**Consultation Response from Mark Berry KC,
Highways Development Management**

2023/92966 Land to the rear of, 271, Cliffe Lane, Gomersal, Cleckheaton, BD19 4SB

Demolition of existing dwelling and erection of 87 dwellings including formation of a new access from Cliffe Lane, landscaping, public open space and all associated infrastructure and engineering works

Date Responded: 15-8-2024.

Drawing Number	152130-001	Rev	A
----------------	------------	-----	---

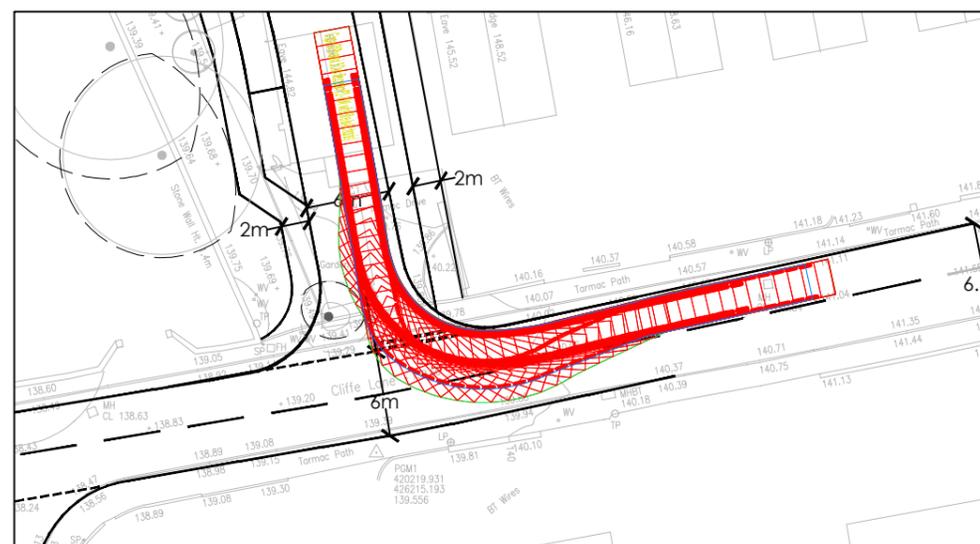
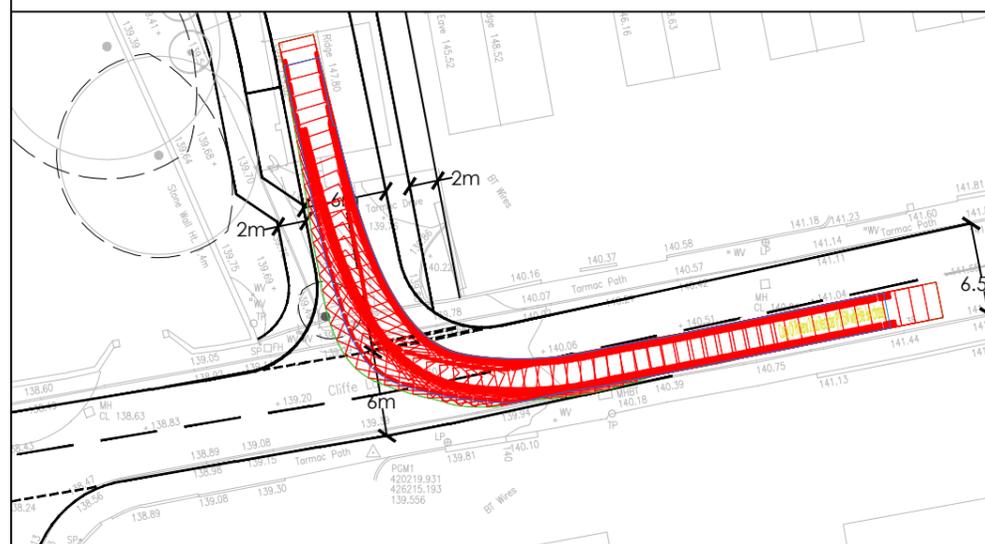
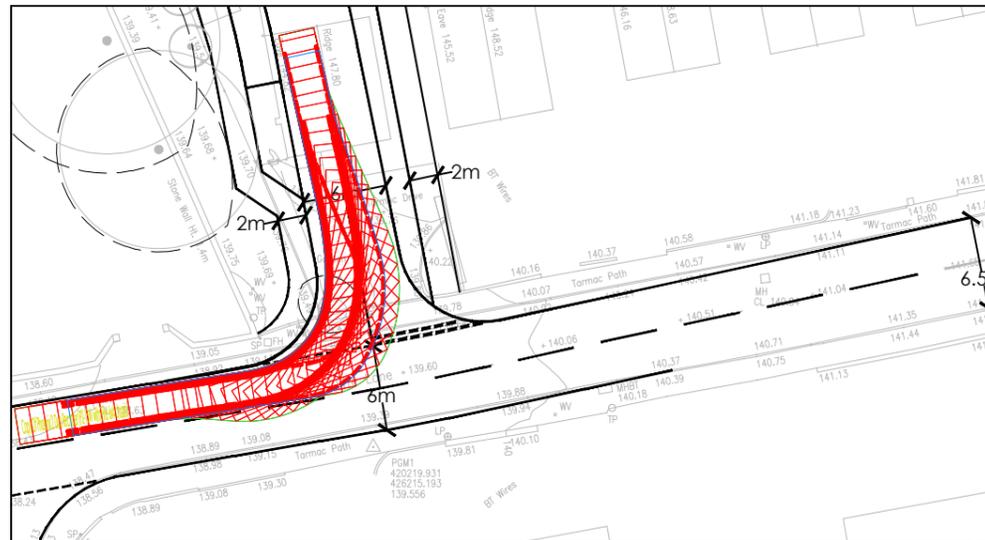
1, Visitor parking should be provided at a rate of 1 space per 4 dwellings or 21 spaces for the 87-dwelling proposed. Visitor parking is still not well spread across the site and the spaces shown within the potential access to the adjacent site next to plot 83 are not considered acceptable. If on-street parking is envisaged, swept path analysis is required to demonstrate if the Kirklees Refuse Vehicle can manoeuvre through.

ROAD 1 - LONGSECTION
SCALE: H 1:250, V 1:250. DATUM: 130.000

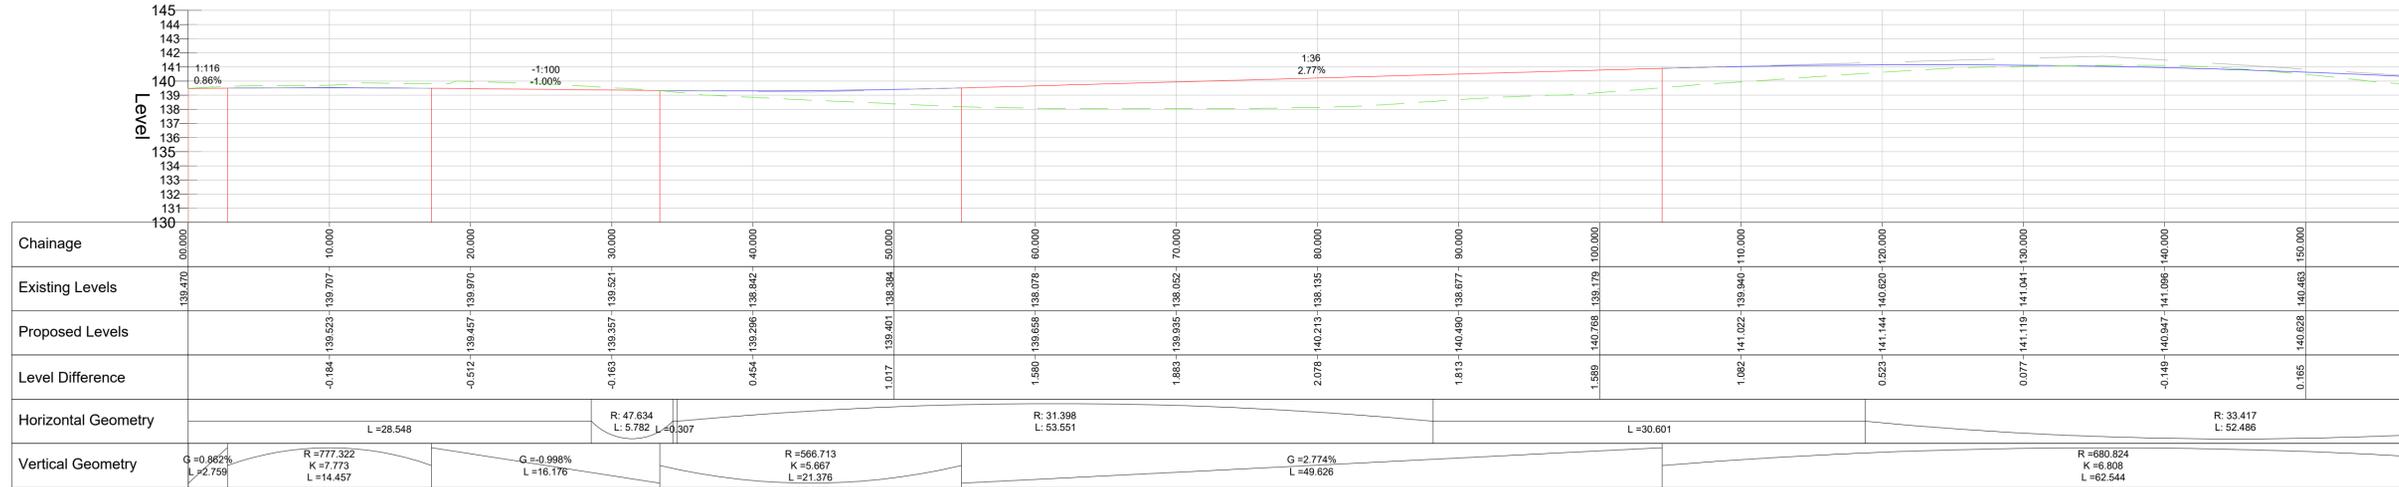
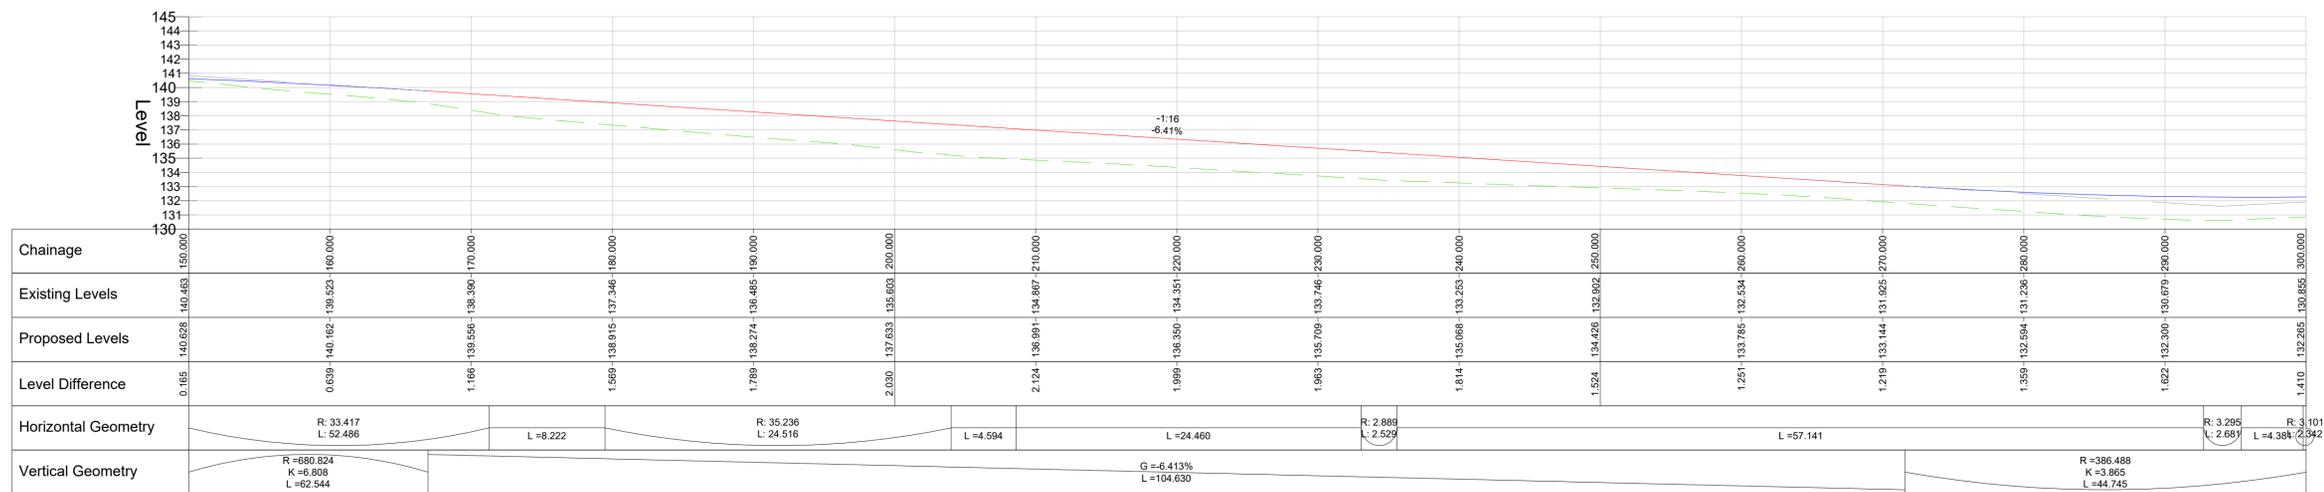
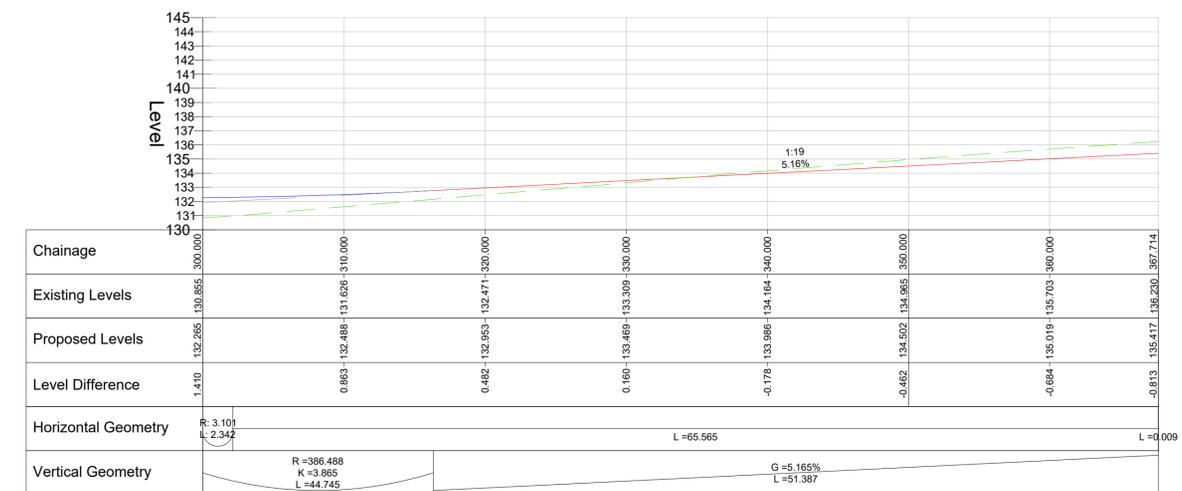
2, The following sections of carriageway are too steep (maximum gradient 5%) for shared surface and will require a typical carriageway estate road with 2m wide footways on both sides of the carriageway as per Table 1 of the Design Guide. This does mean some areas of shared surface will have to be changed to a typical carriageway estate road with footways adjacent the carriageway on both sides or the vertical alignment will have to be amended to a maximum of 5%.

Road 1 – 6.4% Chainage 170.000 – 270.000

Road 1 - 5.2% Chainage 320.000 – 367.714
